Our Case Number: ABP-318758-23

Re: Proposed public realm improvement works known as the "Westgate 2040 Project"
in Drogheda, County Louth

Submission on Westgate Vision 2040

DRAWING
Demolition Plan -
Toilet Block at George's Square

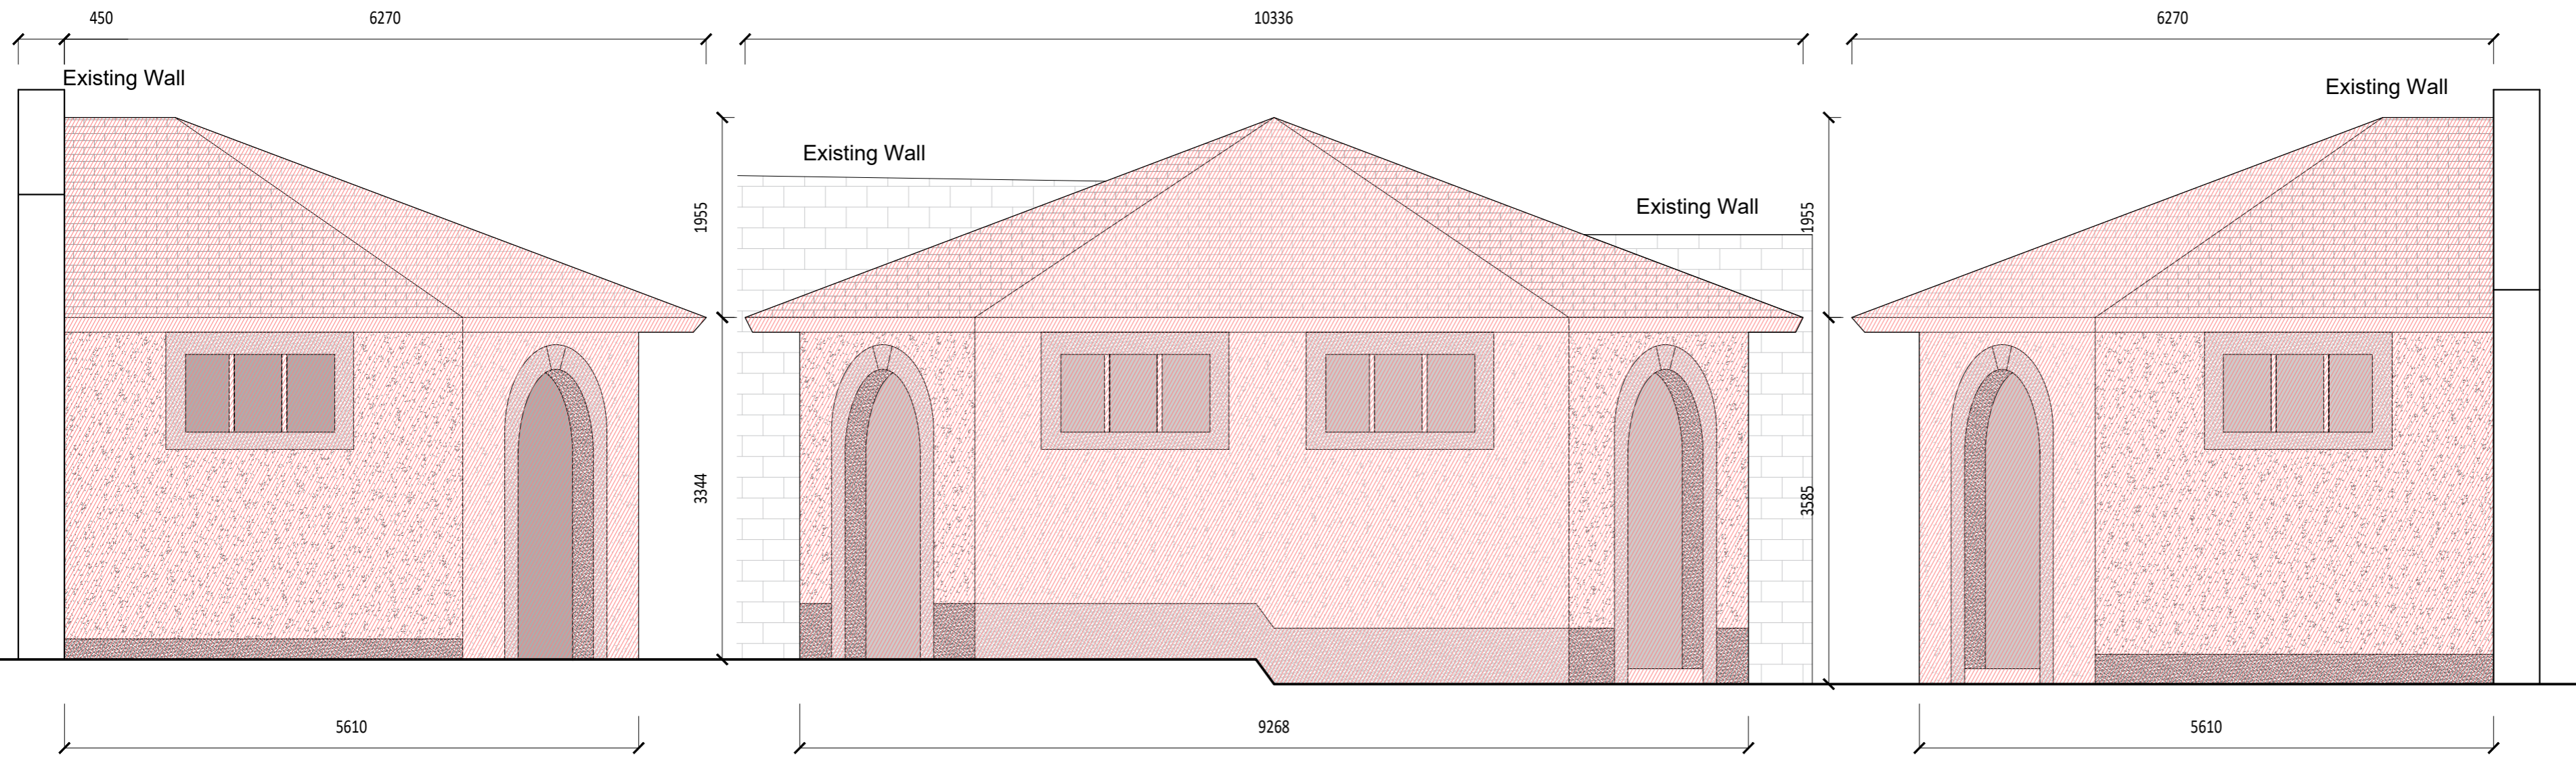
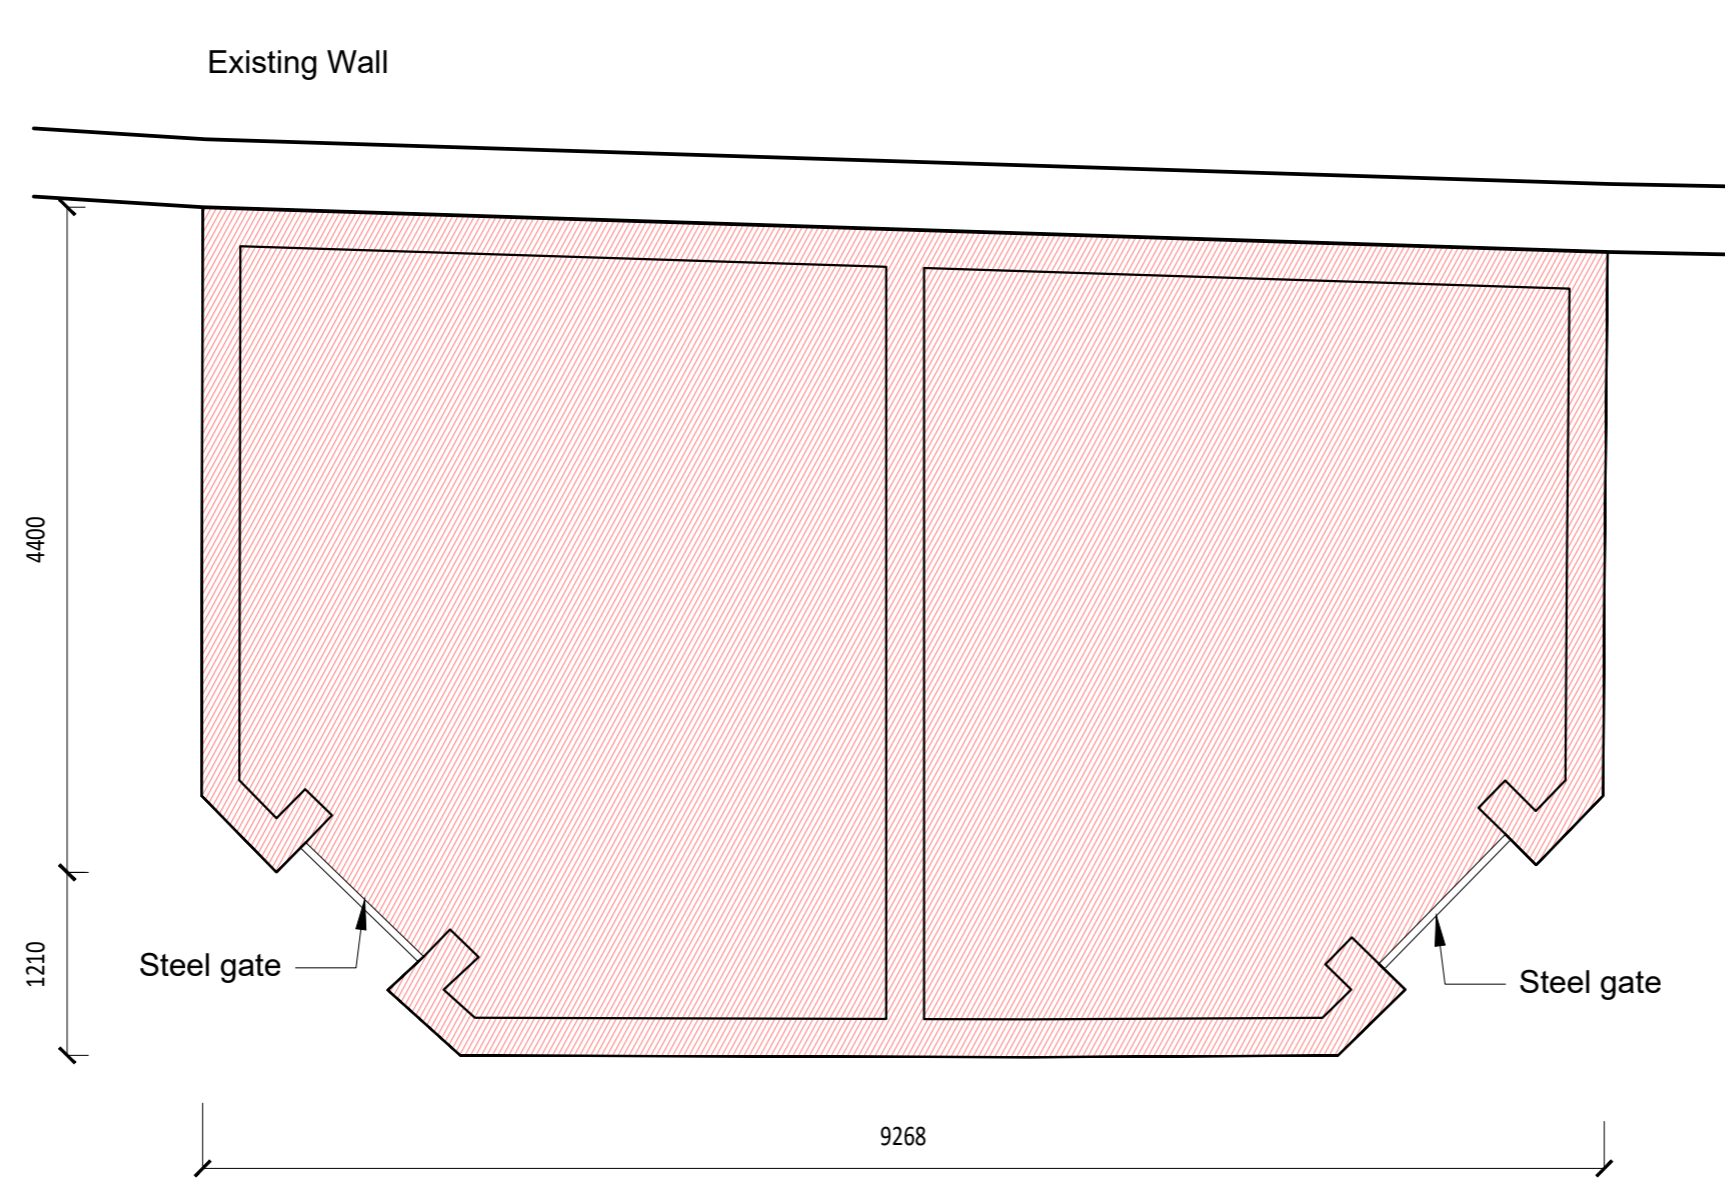
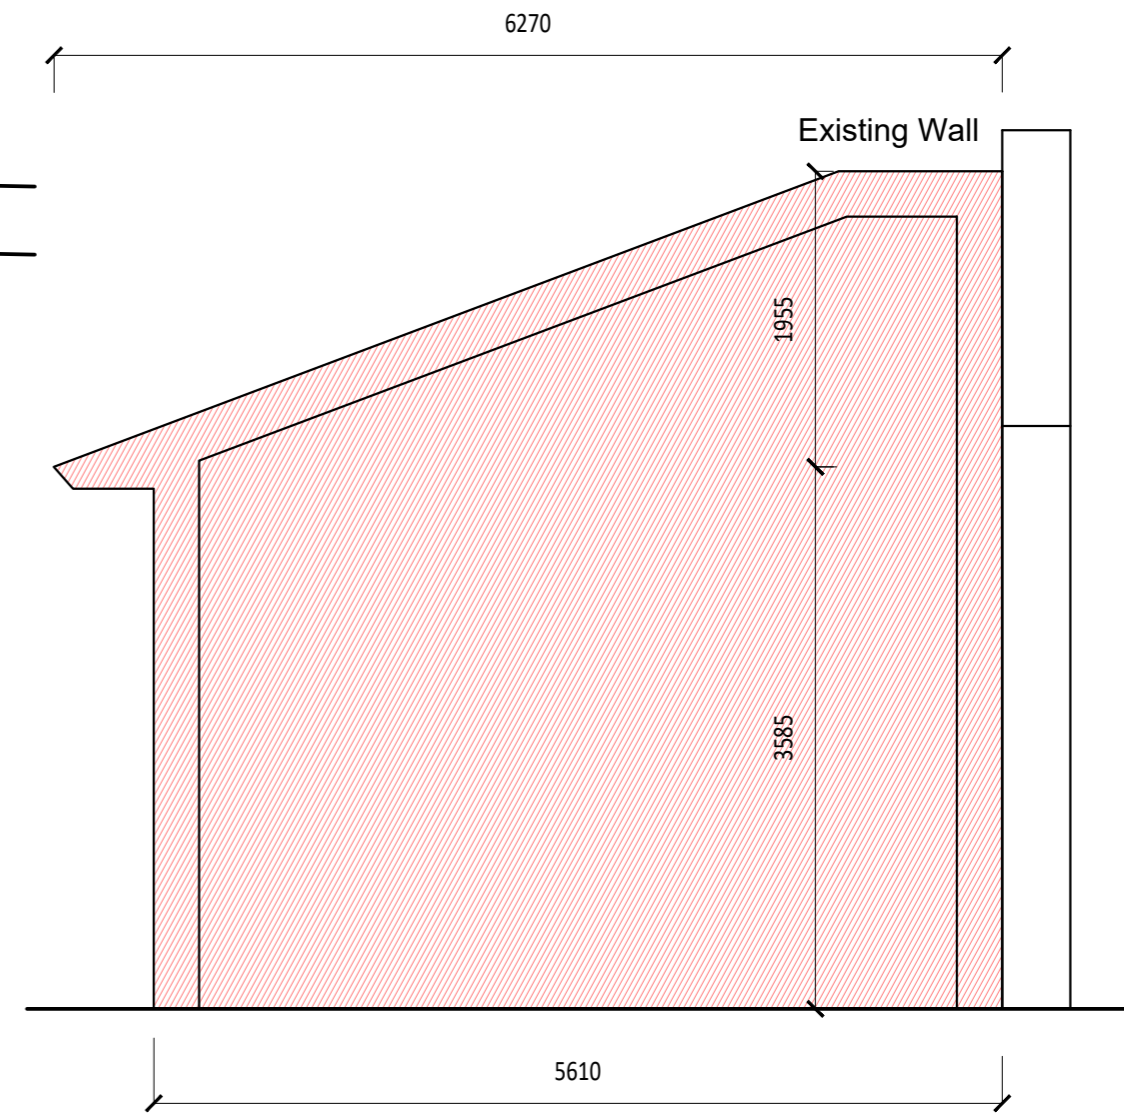
By demolishing an existing public toilet structure that has been in that location on Georges St for many, many decades, albeit shut, and not putting in any other toilet facilities does not reflect the needs of society and the target groups laid out in the plan. Drogheda has no public toilets and I feel that there could have been an aesthetic overhaul of the existing toilets with improved safety and accessibility that would have been functional yet an exciting feature of the Westgate Vision 2040. You only have to do a google search to see how public toilets can be a positive talking feature in other cities.

DRAWING  
Detail Drawing 1  
Corten Steel Structure at West Gate Entrance

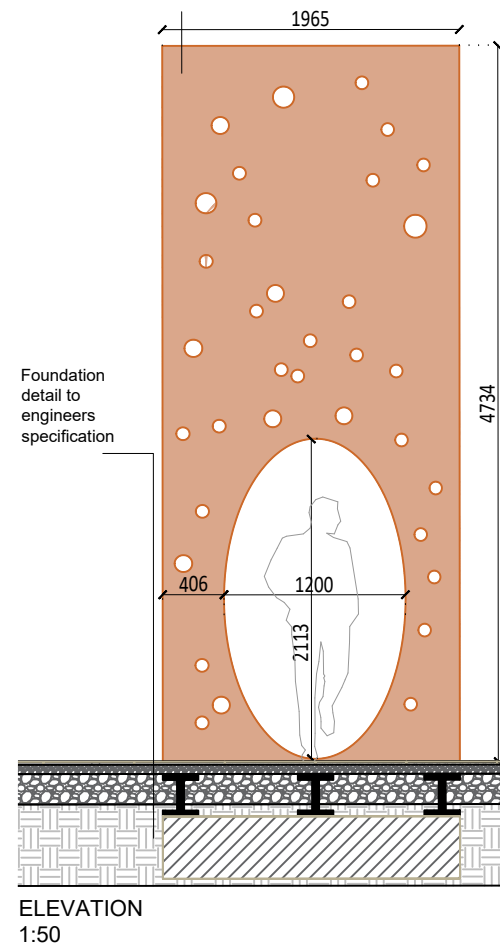
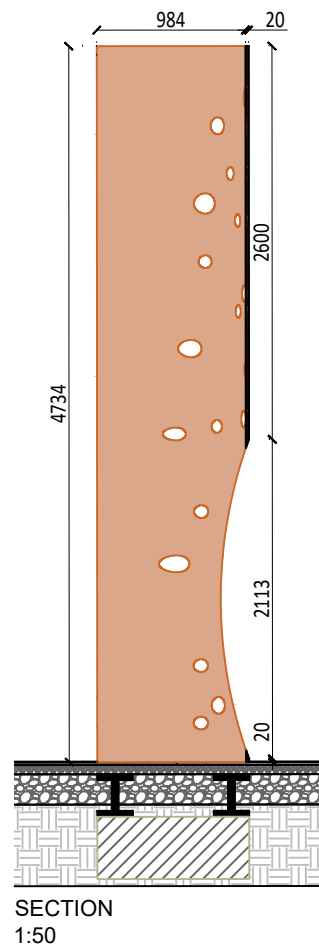
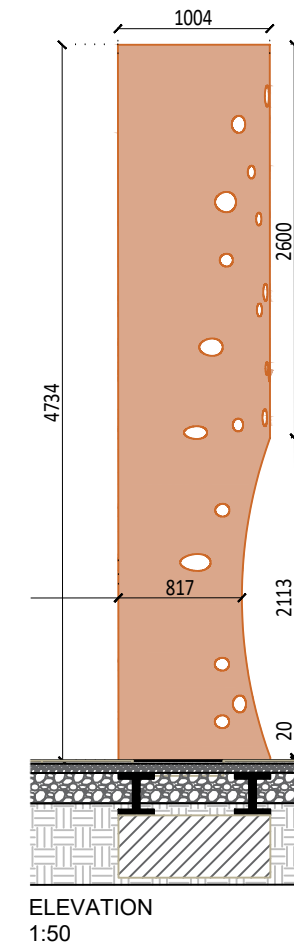
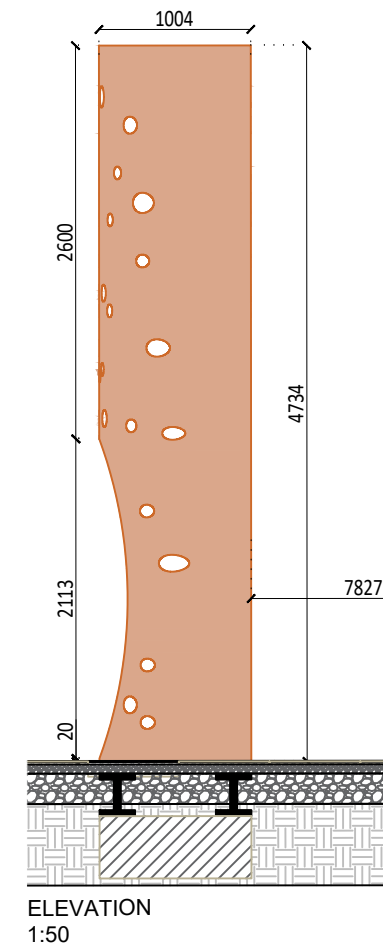
I don't have a clear idea or vision of the sense of arrival at George's St. This is not obvious in the plan to me. The drawings are overwhelming with road markings and less of a clear sense of space and that you are being pulled towards an exciting area of Drogheda. A sculpture reflecting the river or myths associated with the Boyne would be welcome here or large aesthetic signage such as 'Westgate' or similar before entrance to Narrow West St.
